Department of Transportation

SH21A
El Paso County

RE: Trails at Aspen Ridge (Springs East at Waterview)
PUD SP-191 - Description. What is PUD SP?
SF-192 - Description.

<b>LEGACY ROUNDABOUT INTERSECTION SIGHT DISTANCE EXHIBIT</b>			
DESIGNED BY:	SCALE	DATE ISSUED:	DRAWING No.
CHECKED BY:	HORIZ	SHEET	OF
	VERT.

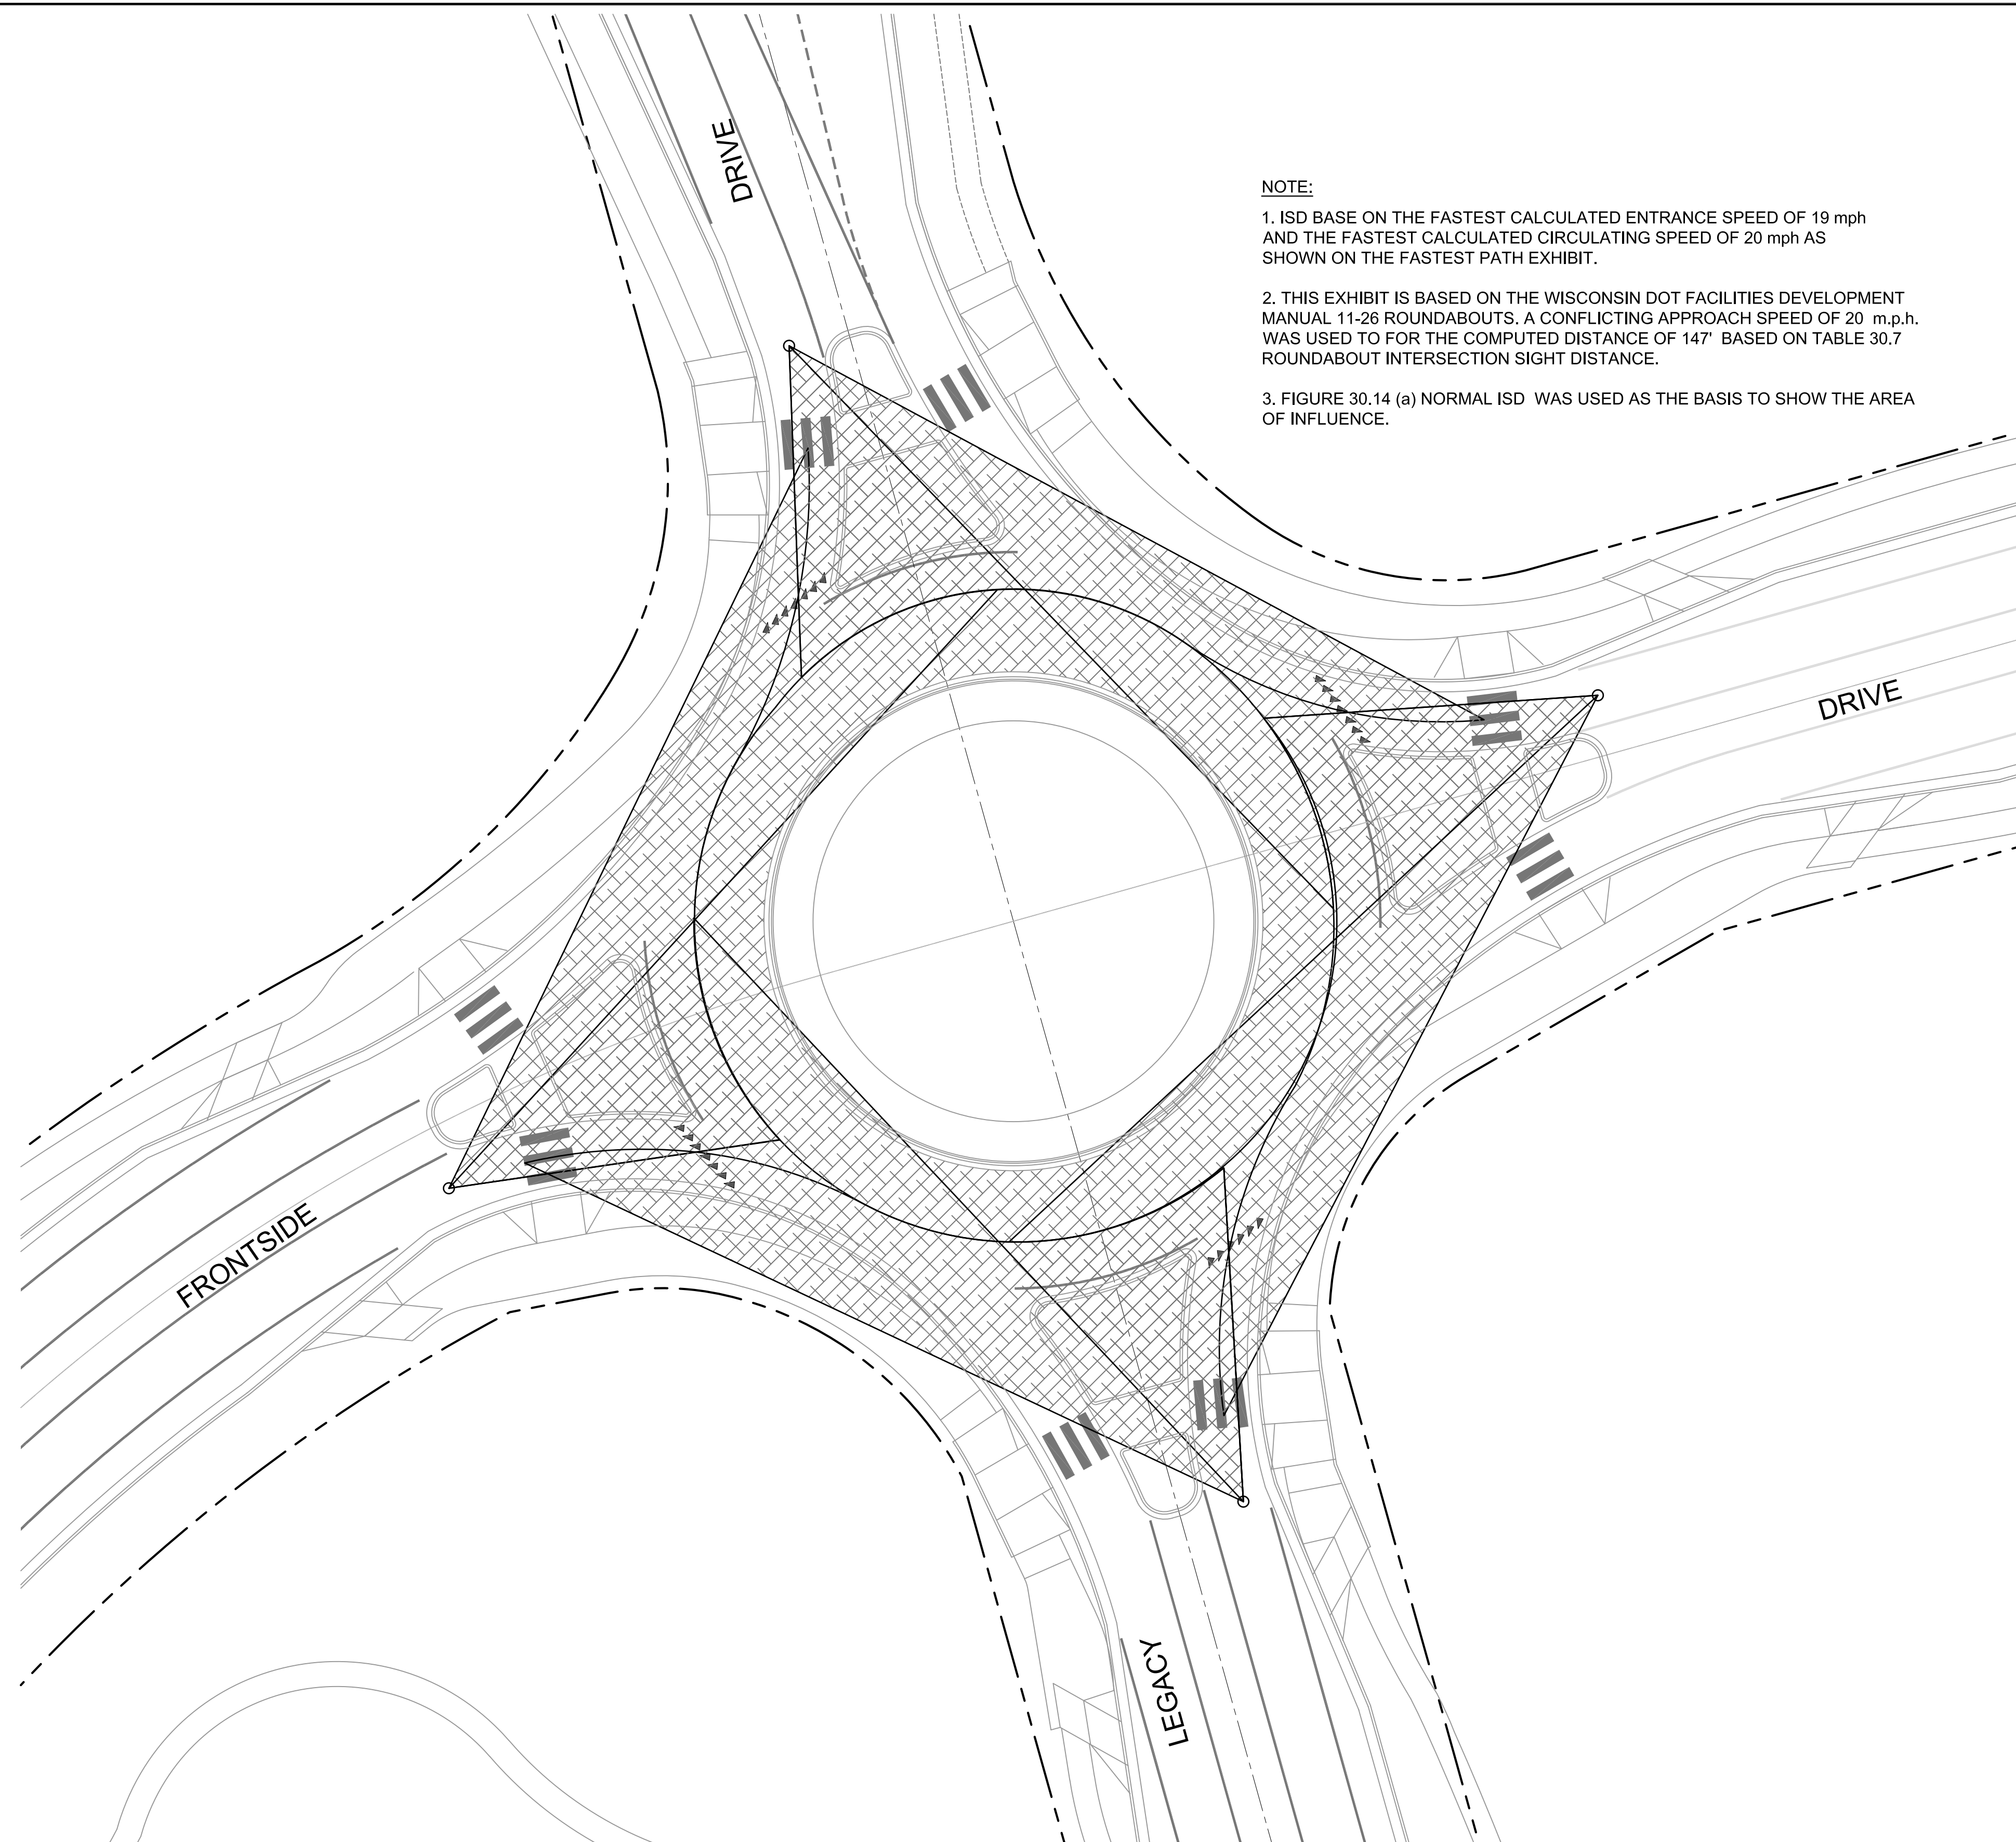
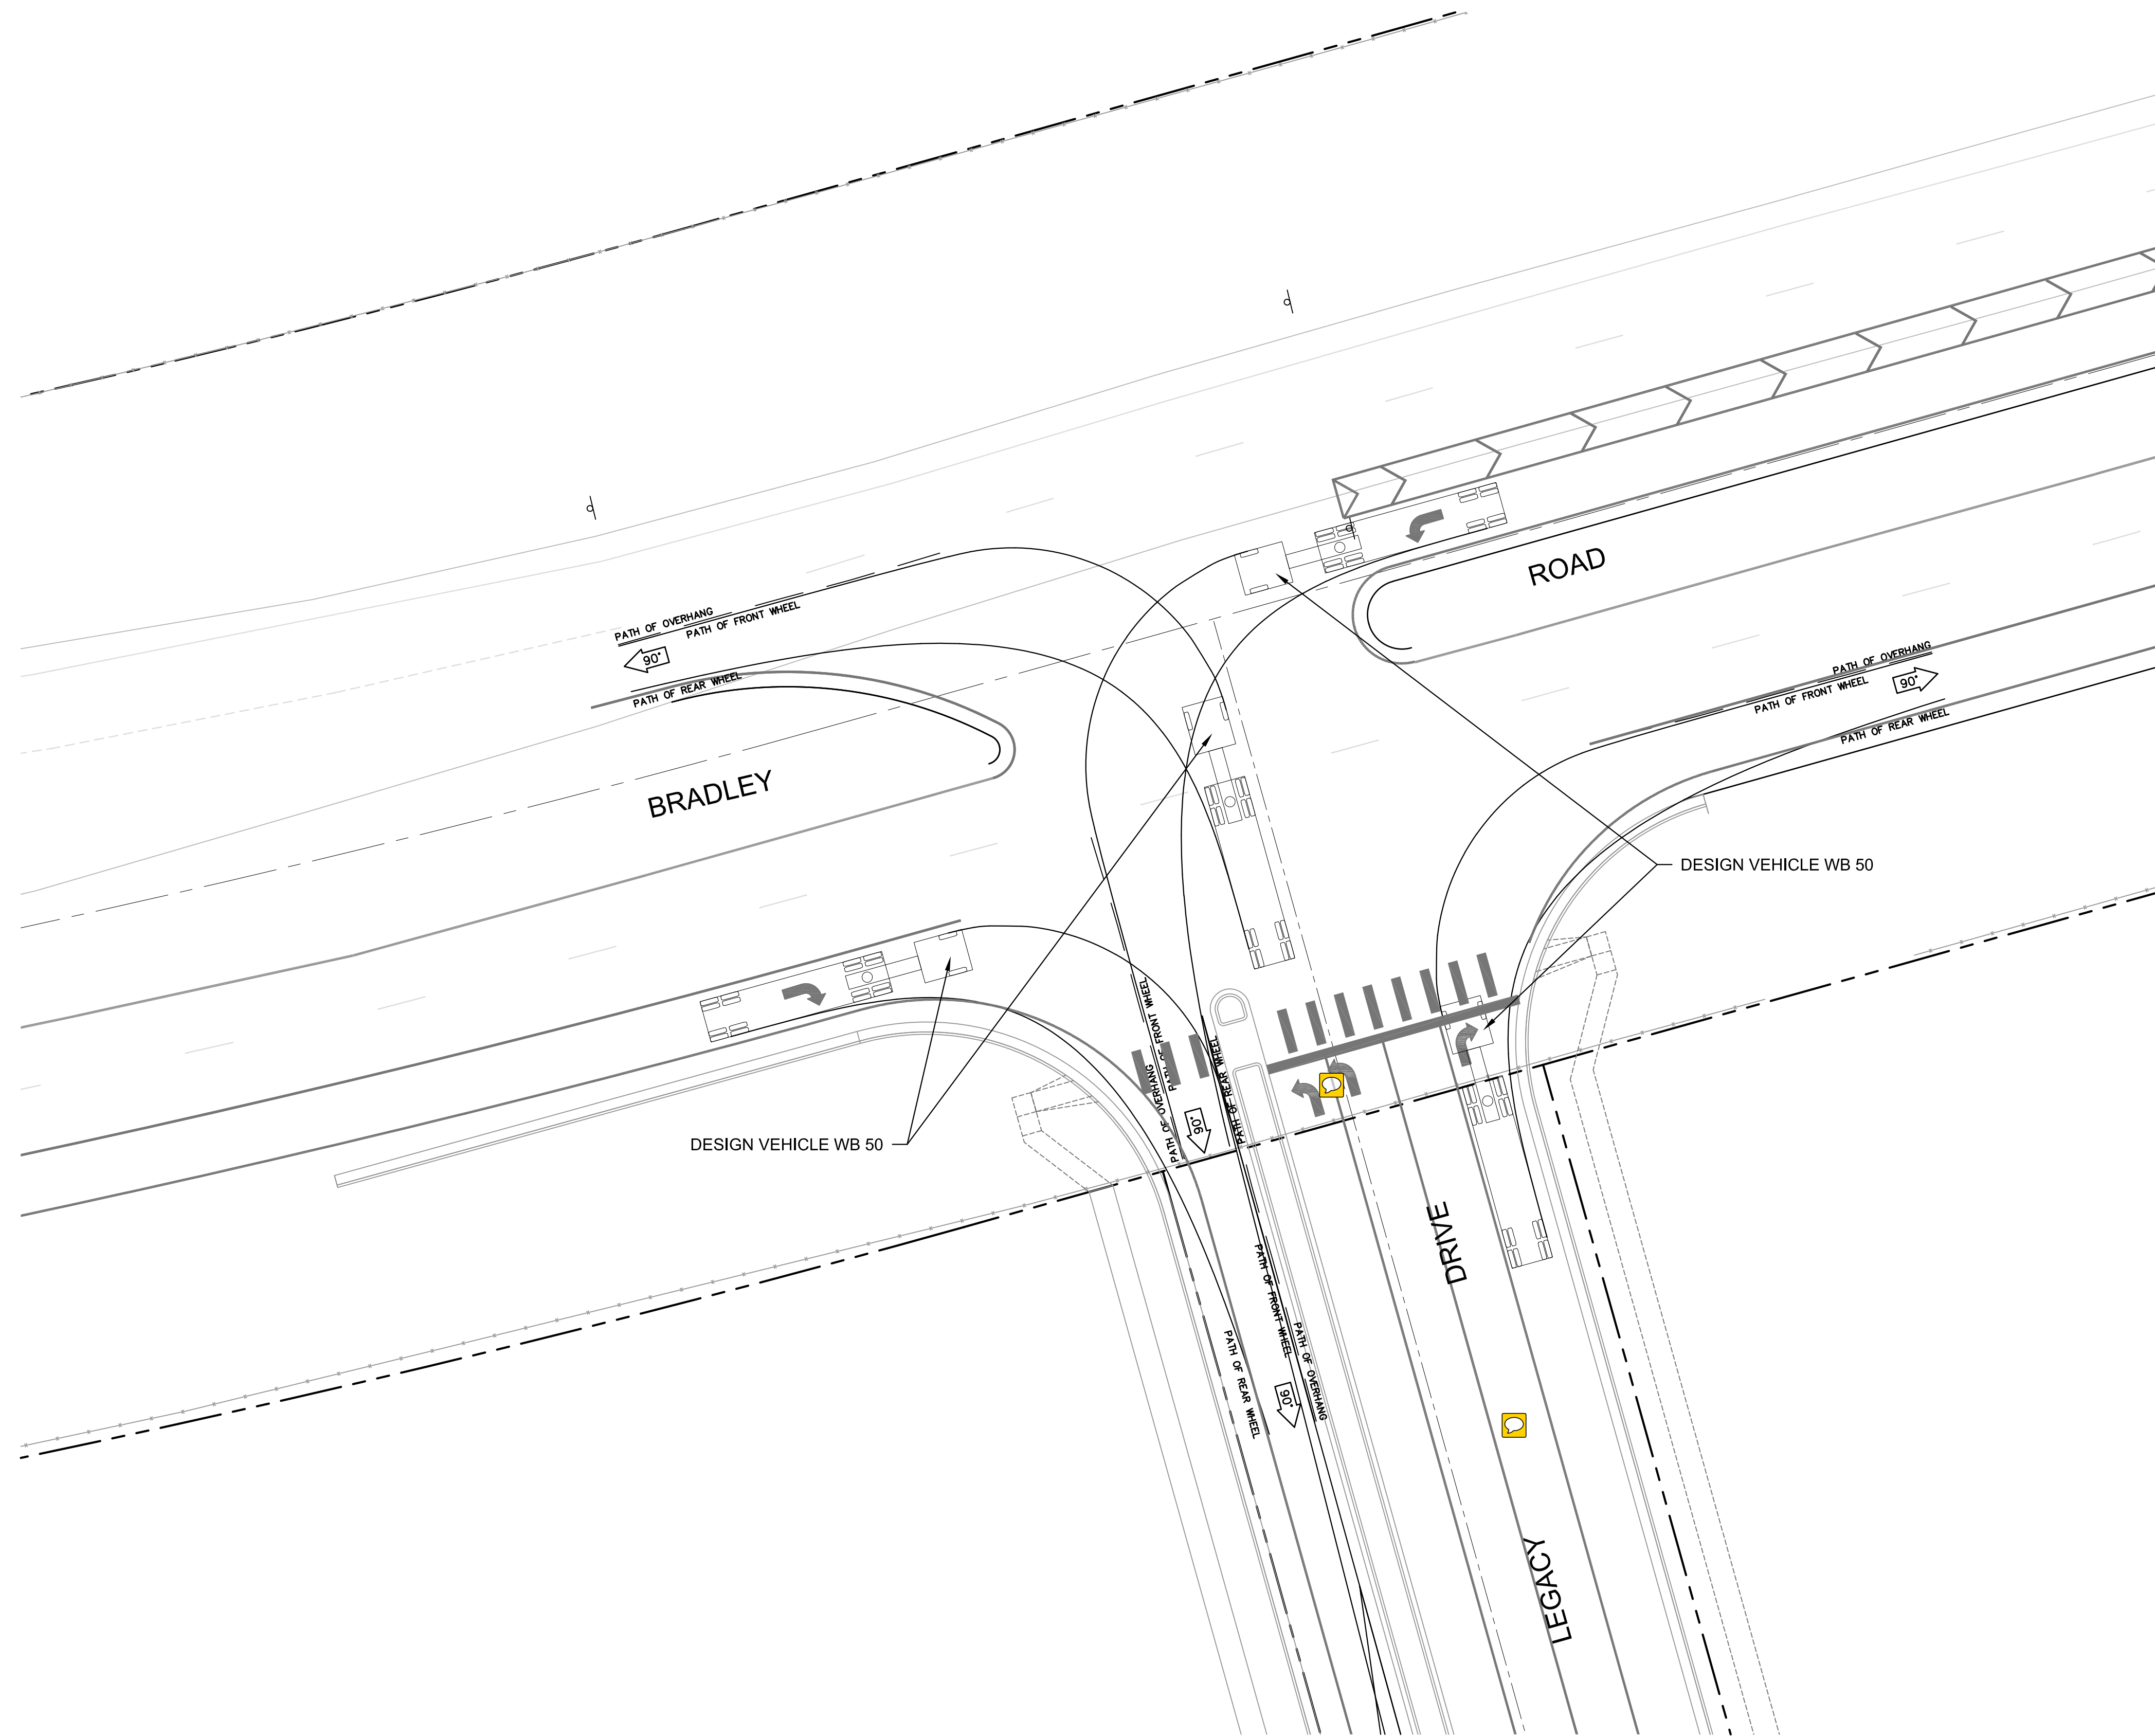
- d. Legacy Hill Drive access may be converted to RI/RO in the future if traffic issues arise or future traffic warrants are met to close this proposed full movement access crossing. Is it possible to pursue a roundabout at this location?
